Re: Tahrah, Maxwell Road, Arundel BN18 9EU
Planning Permission Application Ref: **AB/37/17/PL (Approved)** – Discharge of Conditions and Non-Material Amendments

The following responses relate directly to the Conditions as stated/numbered in the Decision Notice. I have attached the following amended/additional documents (original PLUS 3 additional copies);

Proposed Works to
TAHRAH (formally No.1) Maxwell Road
Arundel, West Sussex BN18 9EU
Drg. No. AB 1 (A)

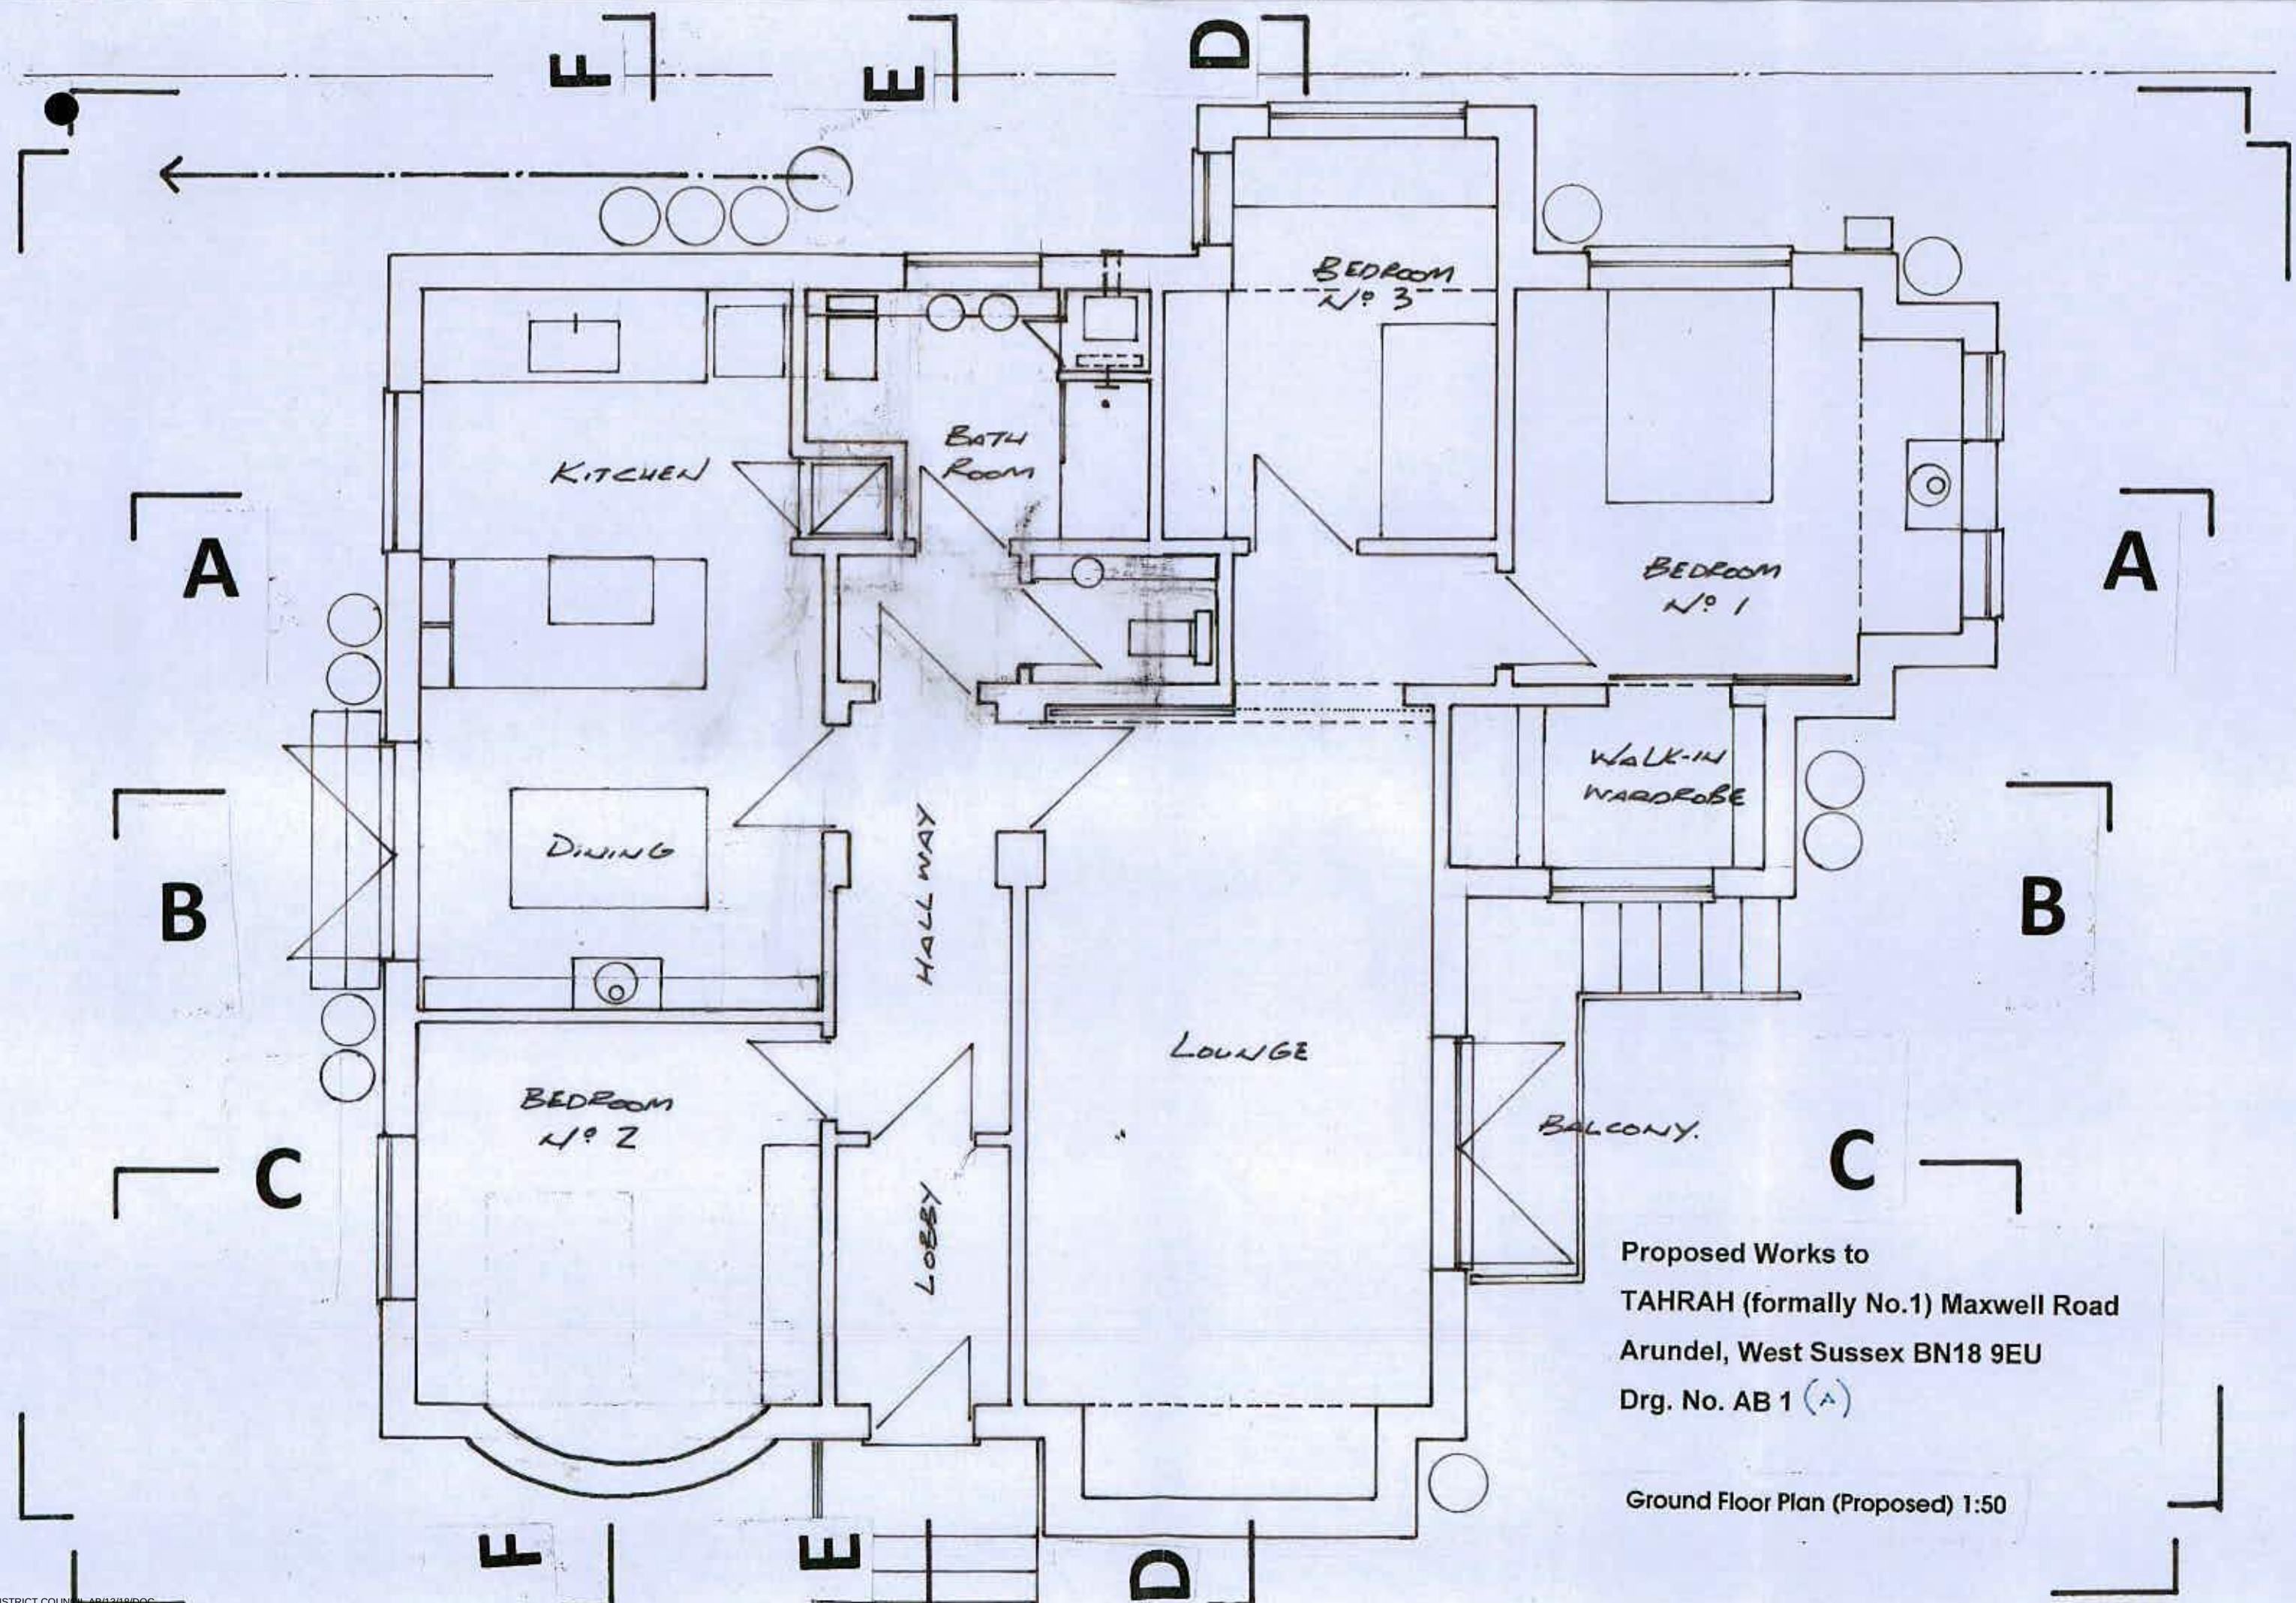
2. The Development shall be carried out in accordance with the stated plans – except for the non-material amendments as discussed/as itemised below;
 - a) The original line of the curved wall of the existing house will be followed. We removed this curved wall in favour of a straight wall as indicated on the submitted/approved plans – but have decided to retain the original curved wall line as it aligns with the original foundations.

**see amended plans, elevations, section and 3D visuals*
 - b) The submitted/approved design indicated that ALL elevations are to receive the “**timber screen cladding**”. We have decided to externally finish the “**out-shoots**” in white render – in order to bring contrast to the elevations.
